PRE-HEARING STAFF ANALYSIS

Rezoning Petition No. 2005-150

Property Owner: Mt Holly Developers, LLC

Request: I-1, light industrial and R-3, single family residential to CC, commercial center, B-2 (CD), highway business conditional district and MX-2, mixed use district

FOR PUBLIC HEARING
PETITION NO. 2005-150

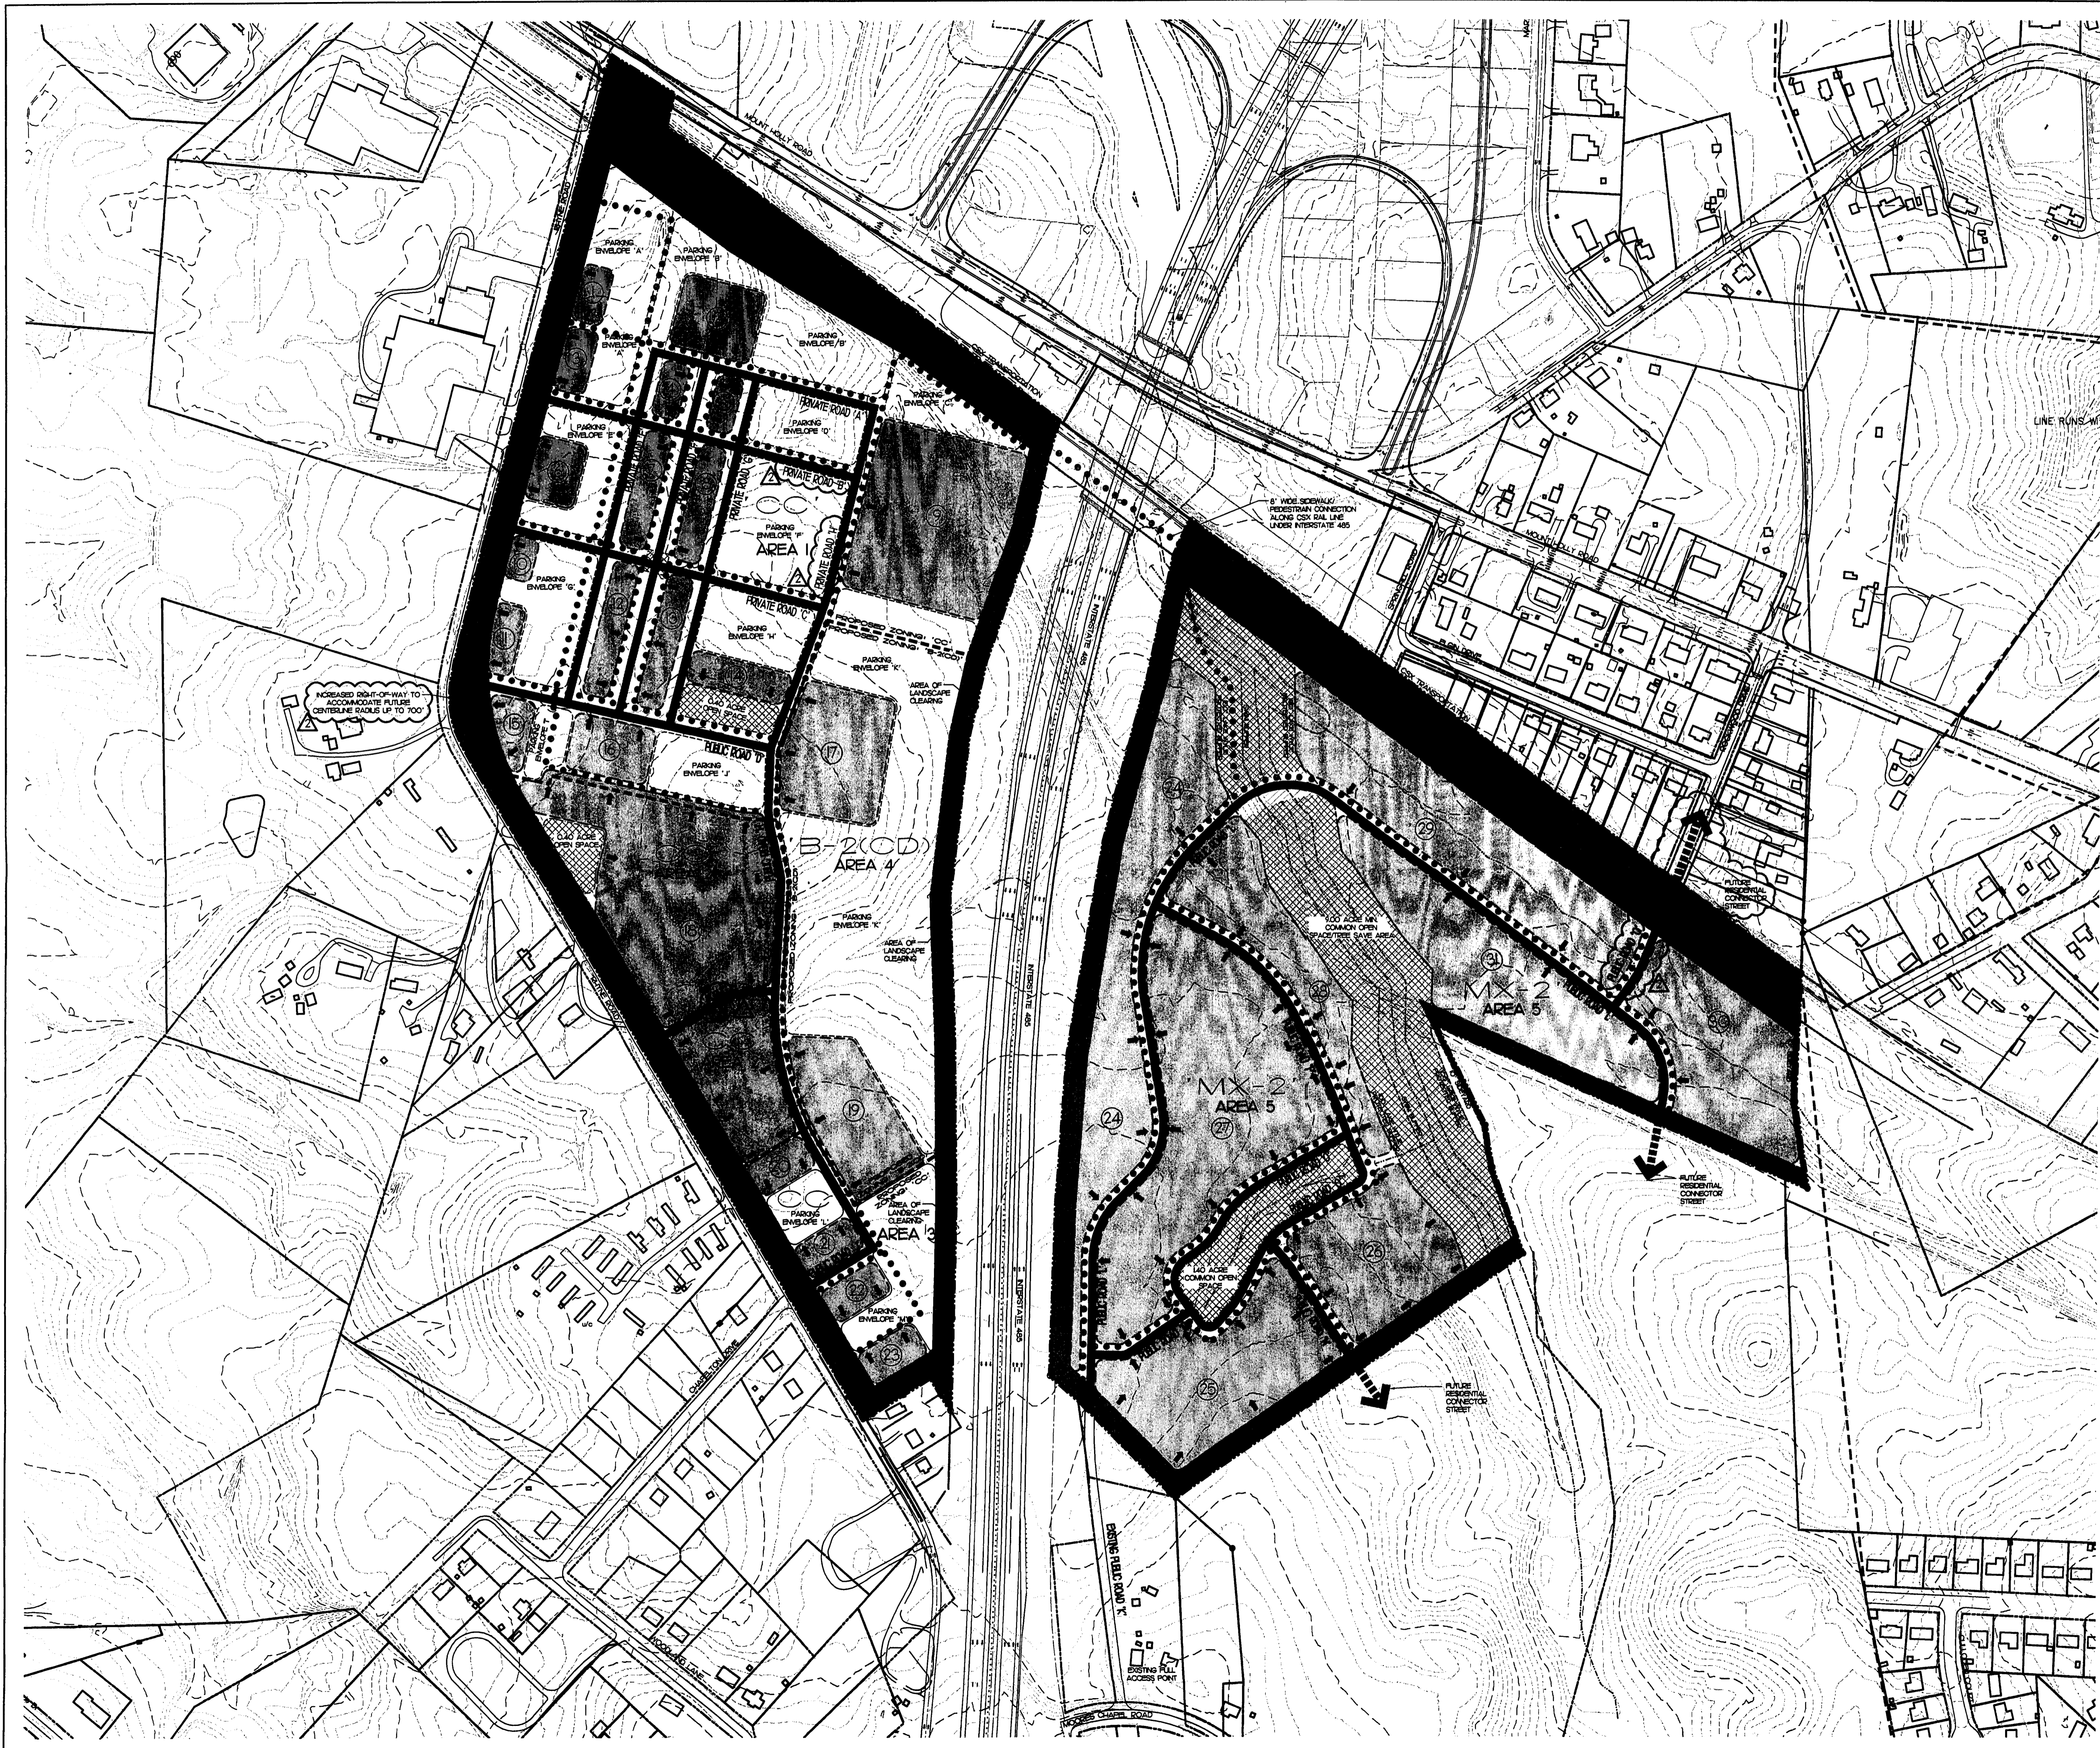
- Orient buildings to the street if the center is located on a pedestrian-oriented type street with pedestrian access. To create a human scale streetscape along Rhyne Road move buildings close to the street with parking to the rear and side. Provide pedestrian entrances to the buildings. Design the facades to compliment the residential context of the street.

- Storage for the auto dealerships should be at the rear of buildings. The buildings should face the street. Provide site plan indicating proposed building edges.

- The dealerships should be placed closer together to form a cluster with a vehicular connection at the rear of the properties that links all commercial uses (auto and anchor retail).

- The proposed location of the open space on private street “c” appears to have no context. It should be surrounded by retail and/or residential uses-not parking lots.

- Identify tree save opportunities in area 5. Indicate locations of proposed 15% tree save area.
- Note in the site development summary that the property is located in the watershed.

- A schematic site plan illustrating the layout of the proposed buildings and uses should be provided.
- The building setbacks along I-485 should be labeled as tree save areas.

Automobile Dealership Elevation

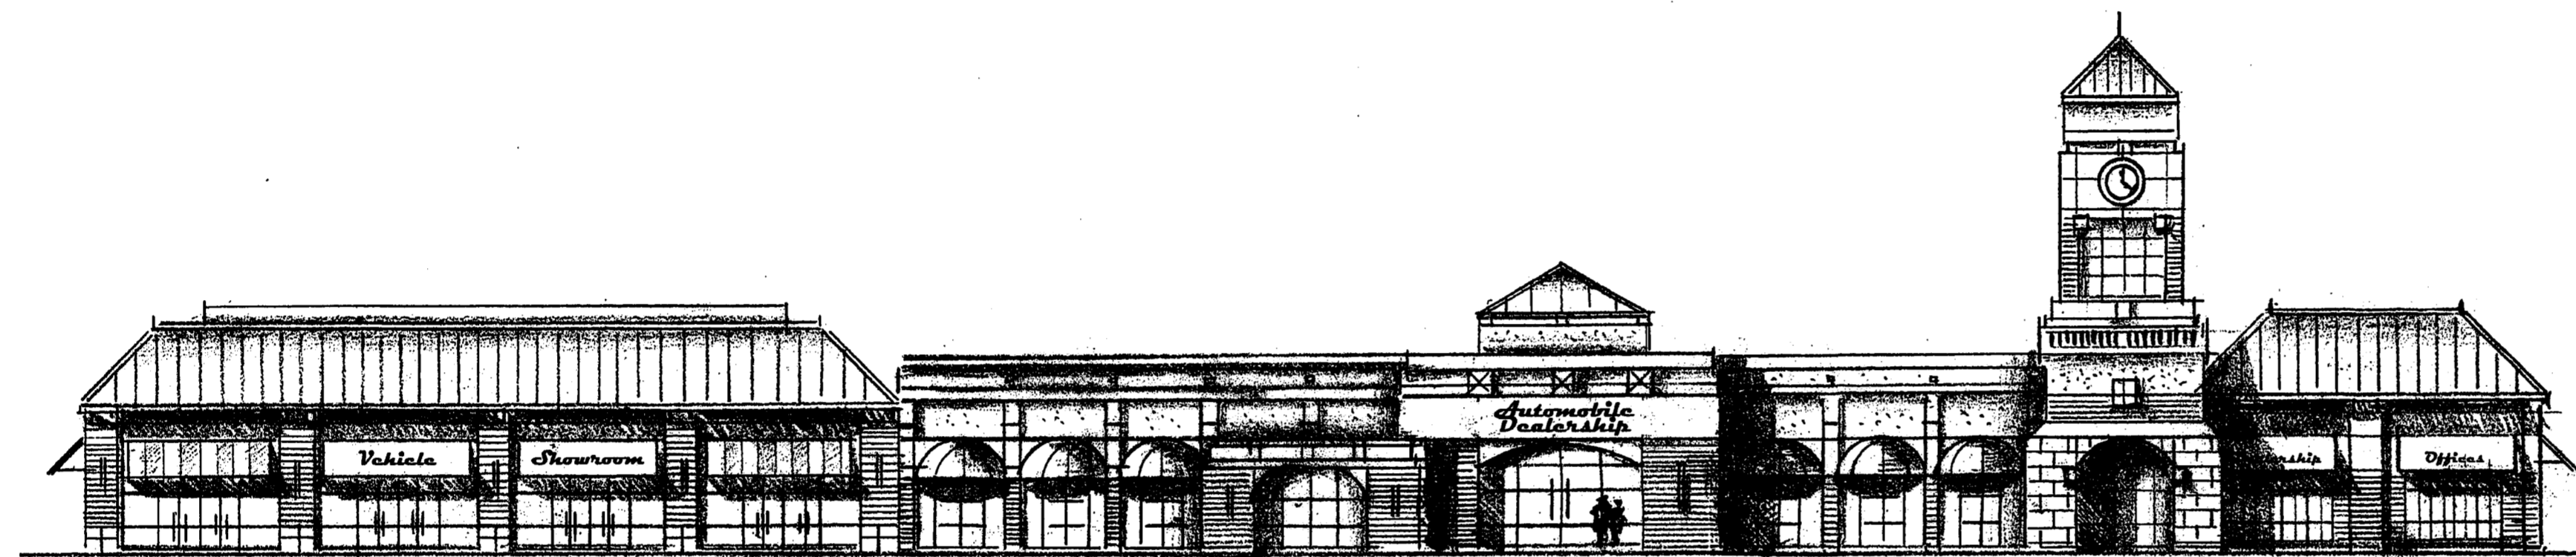
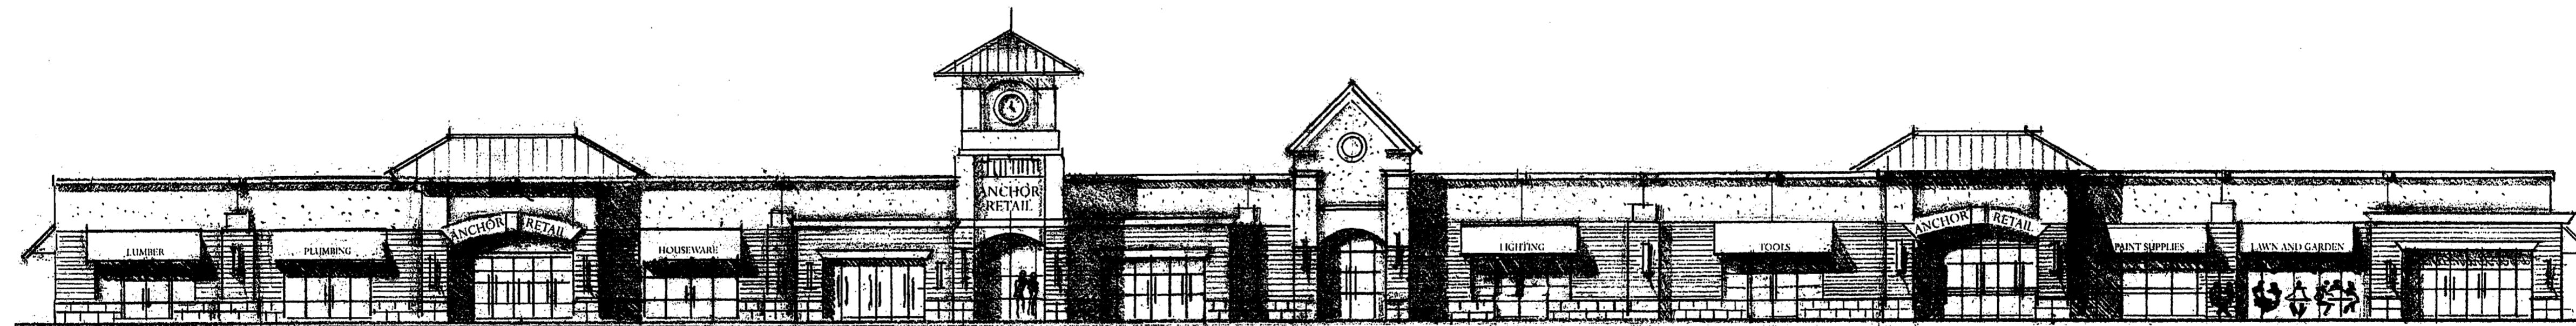
- Create buildings with transparent openings, ornamentation and architectural character. Create entrances that have pedestrian interest. Provide building elevations. Anchor retailers and car dealerships should increase the standard level of design to create a place of interest.
